# CITY OF ALBUQUERQUE

February 23, 2015

**Re: Smiles for Kids Dental Office  
Conceptual DMP and Conceptual Grading Plan  
Engineer's Stamp Date -no stamp- (C12D054)**

project title
Smiles for Kids Dental Office
9201 Eagle Ranch Road, NW,
Albuquerque, New Mexico 87114
sheet title
Conceptual Grading Plan

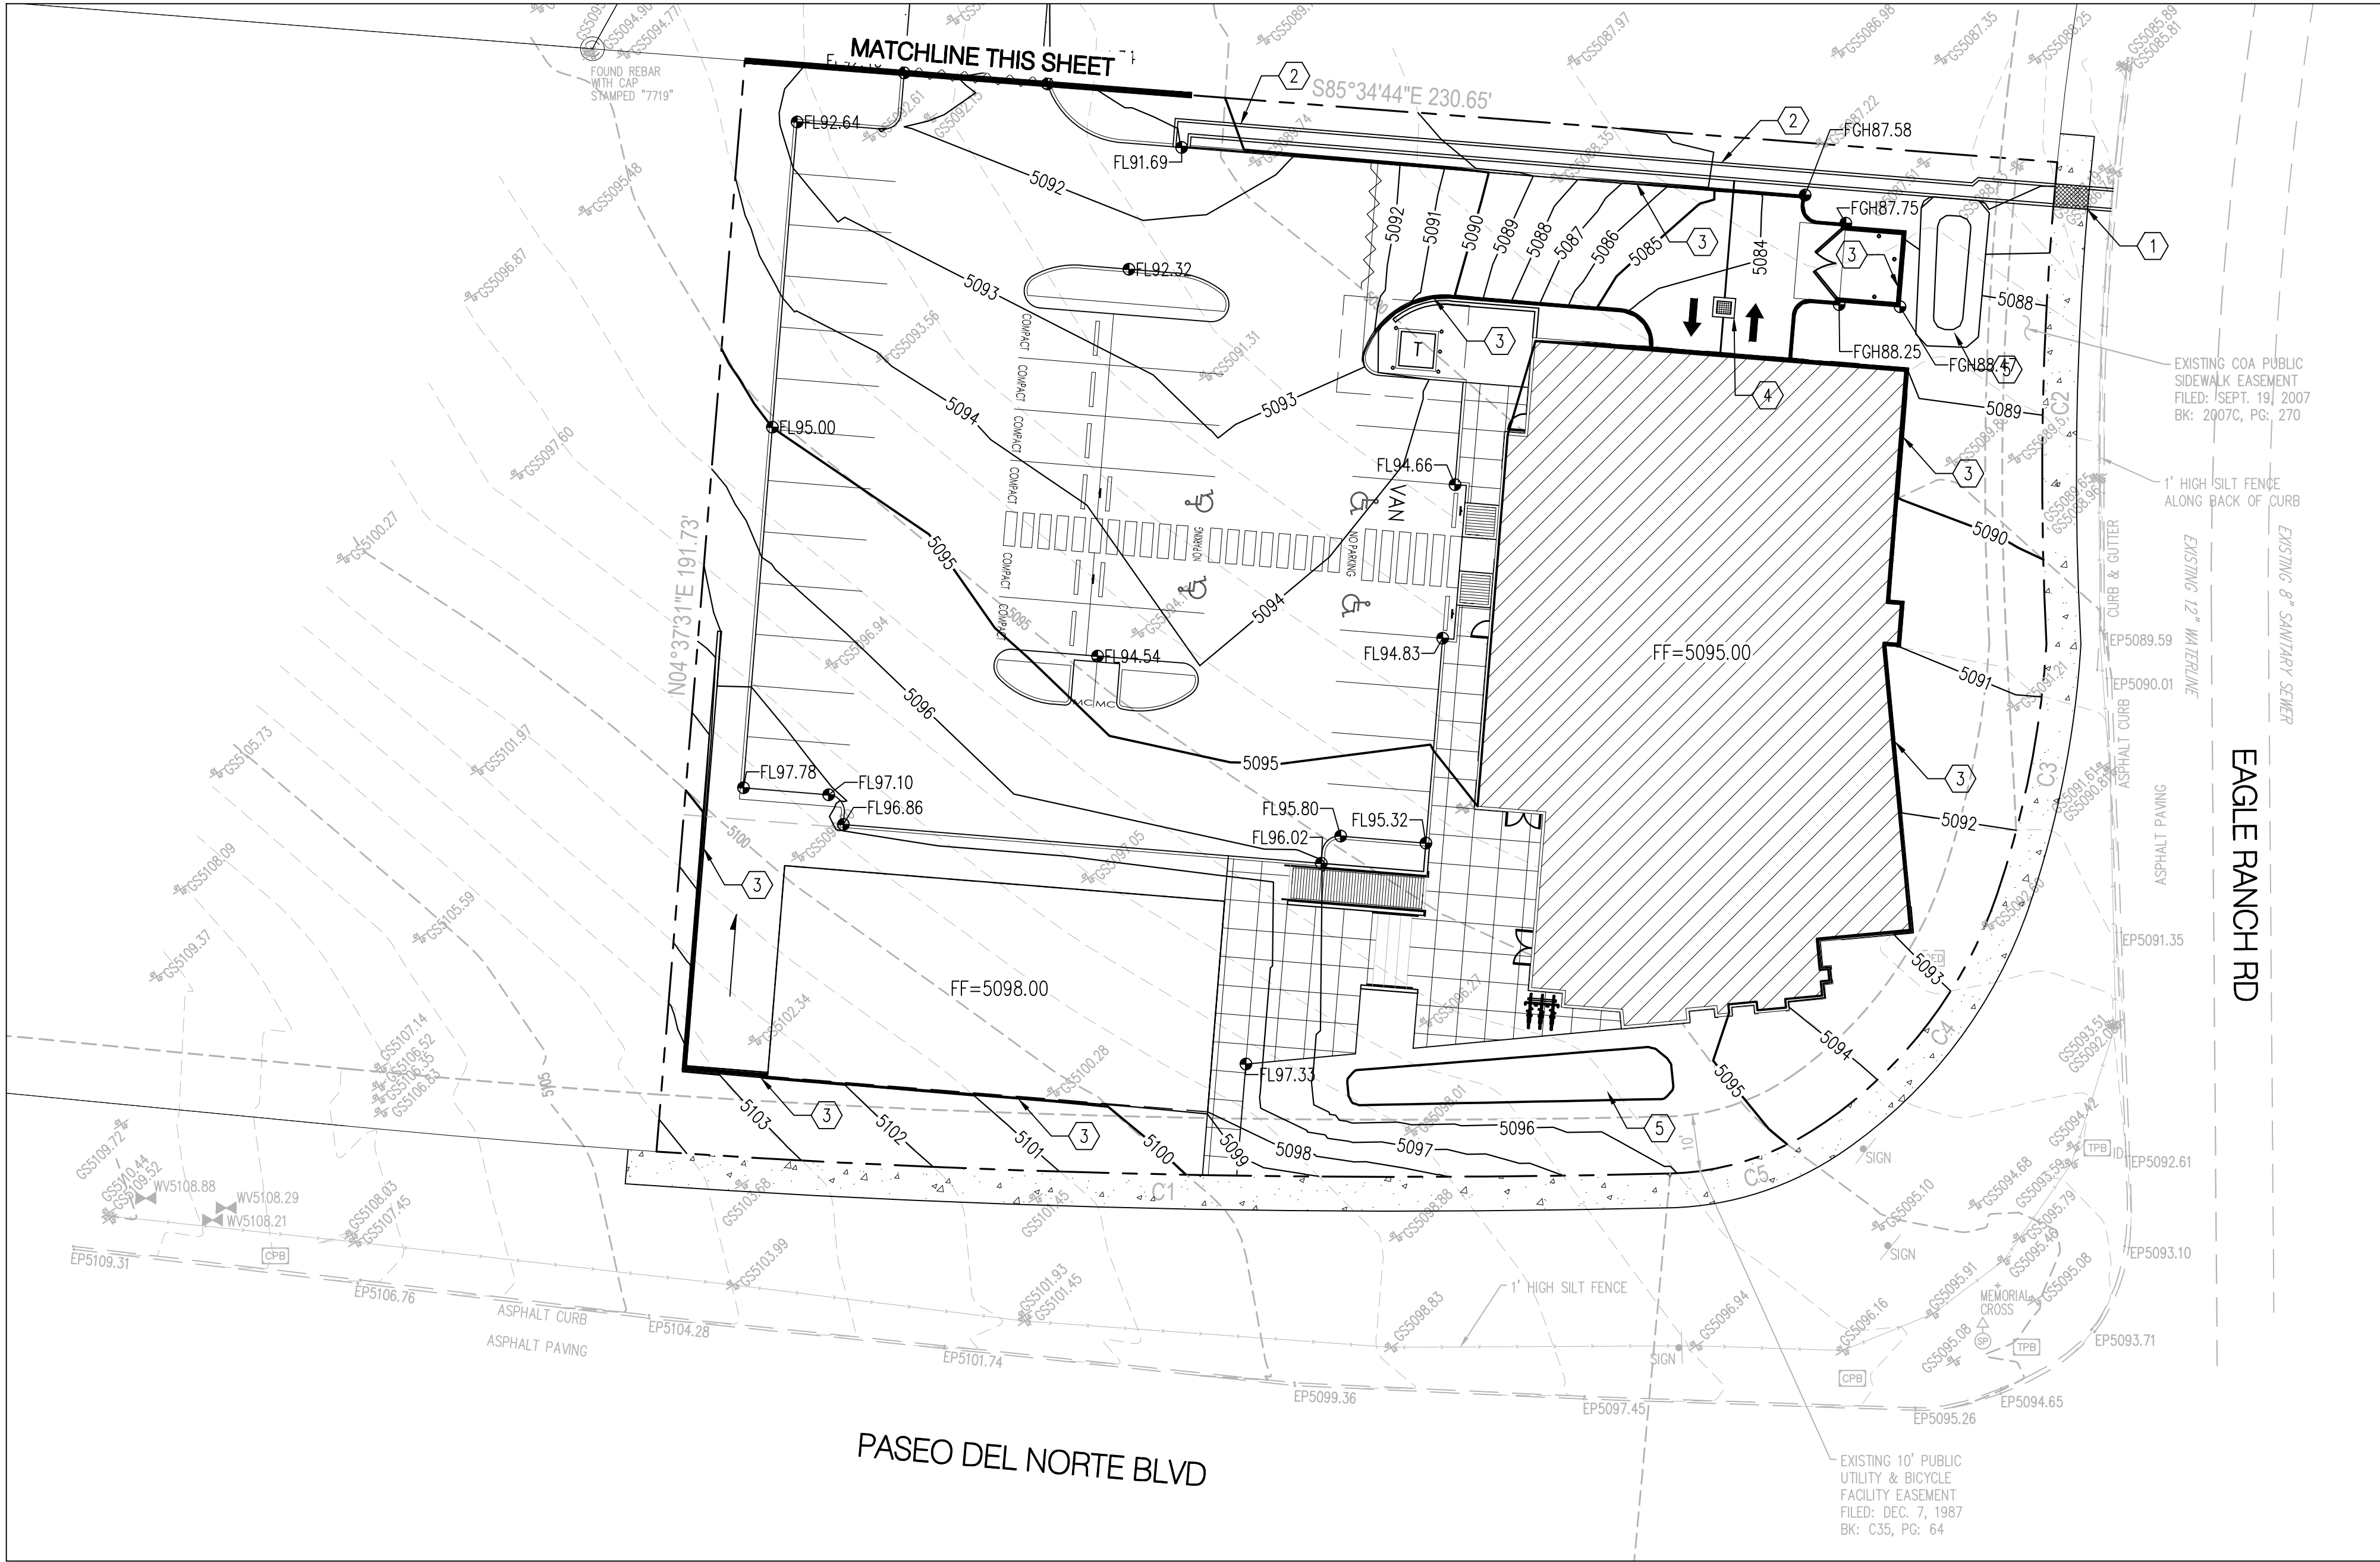
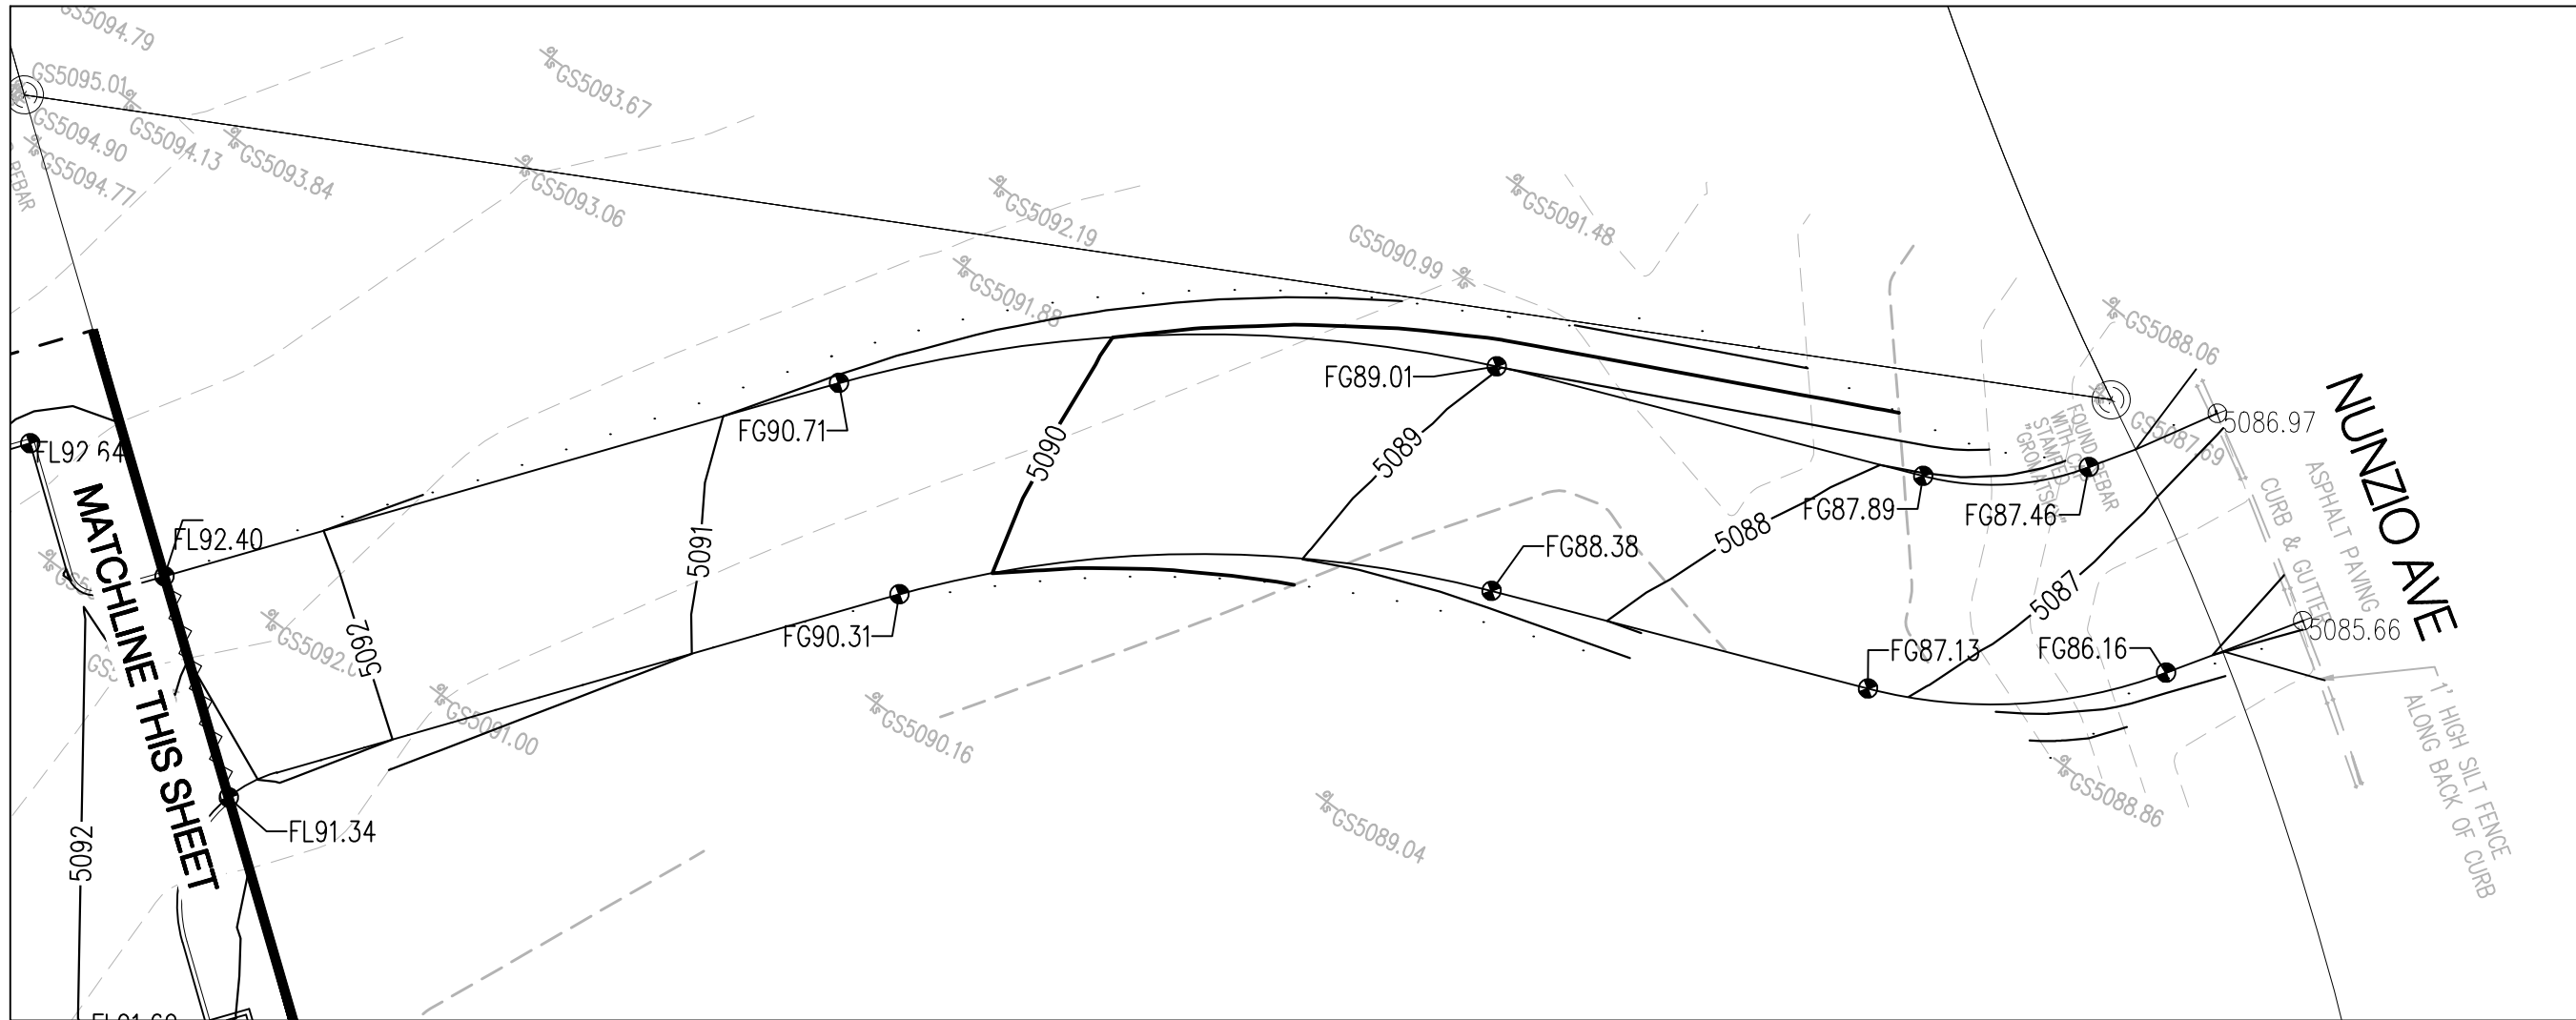
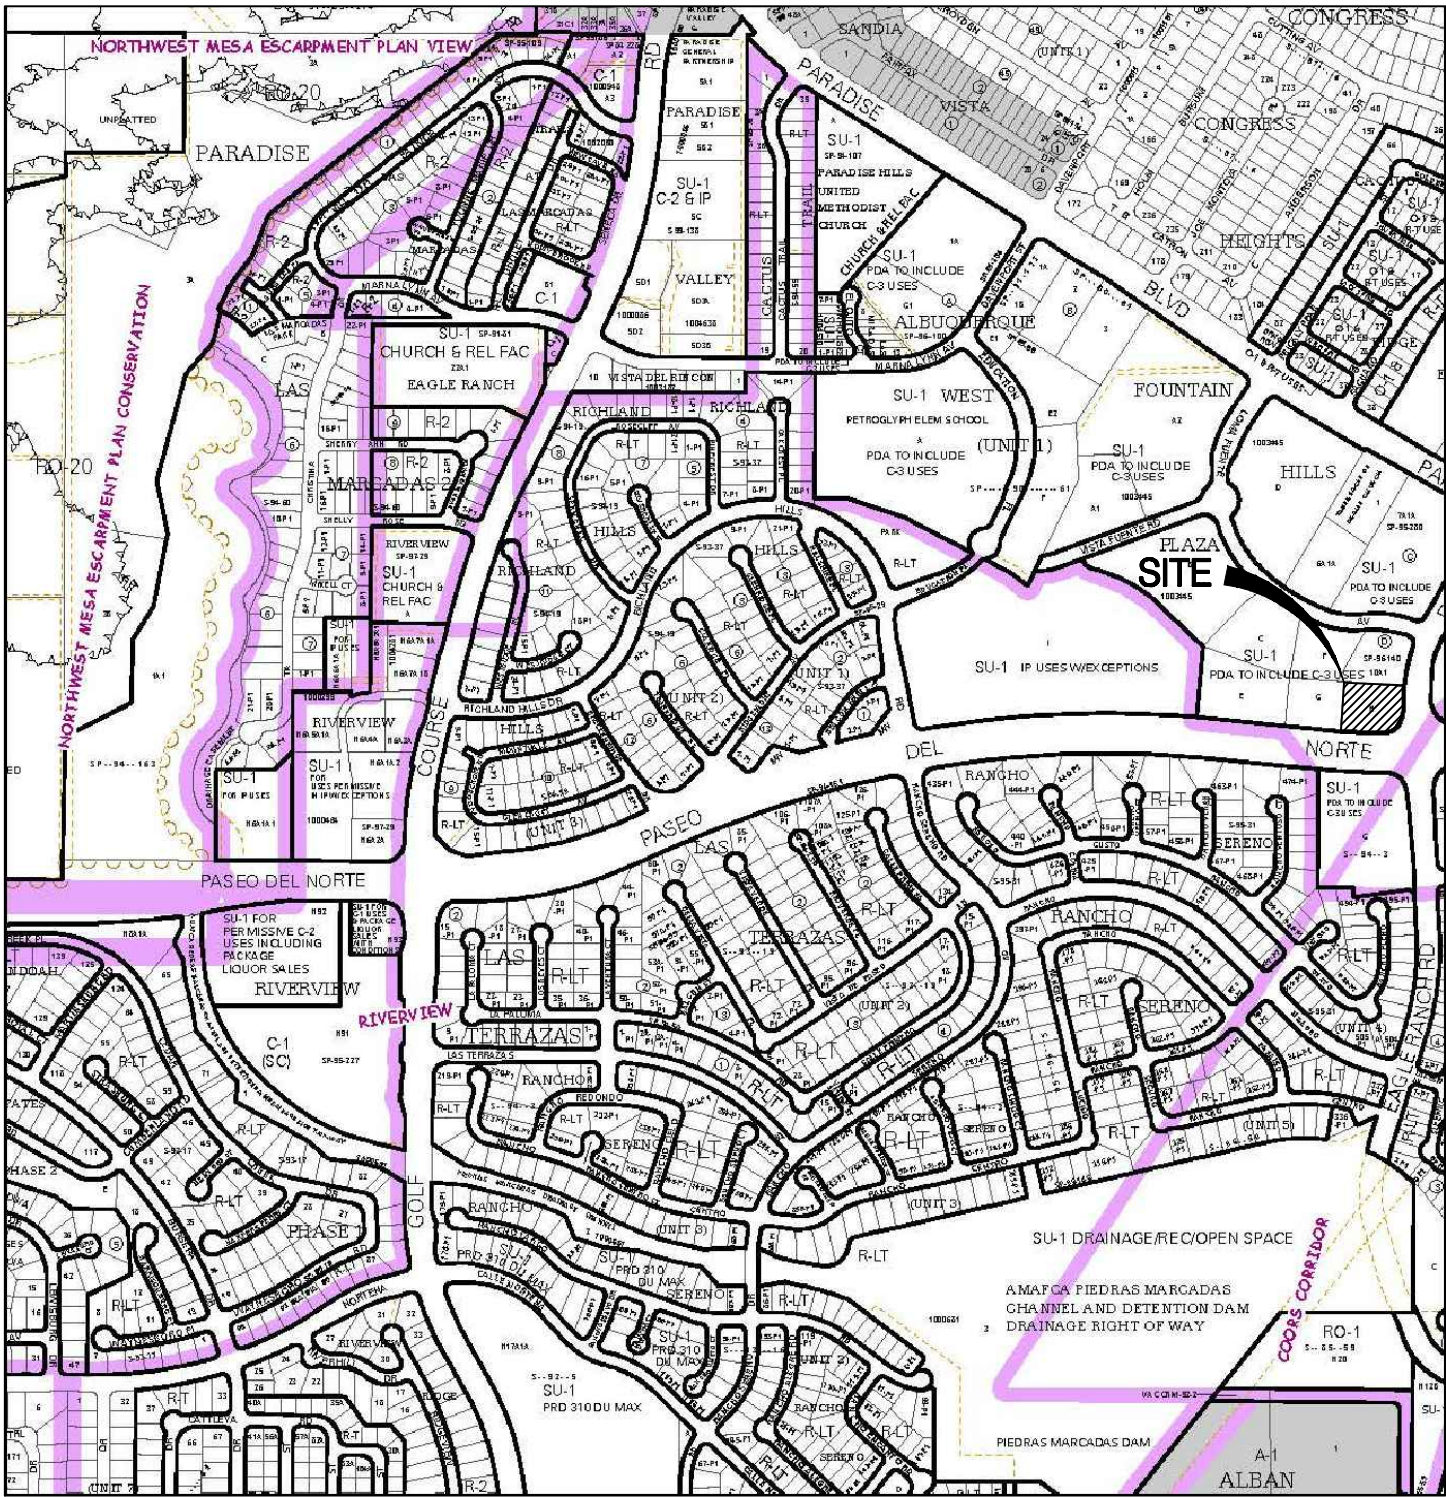
1. Provide the direction of roof flows.
2. Provide calculations for the channel and the sidewalk culvert.
3. Demonstrate, with a detail if necessary, how runoff from the landscape area on the east part of the site will enter the channel.
4. Explain why one building is hatched and the other is not.
5. Provided build notes for the curb cuts in the parking island that will receive the first flush.
6. Show curb, permanent or temporary, to be built on the access drive to Loma Fuente, at least on the downhill side.
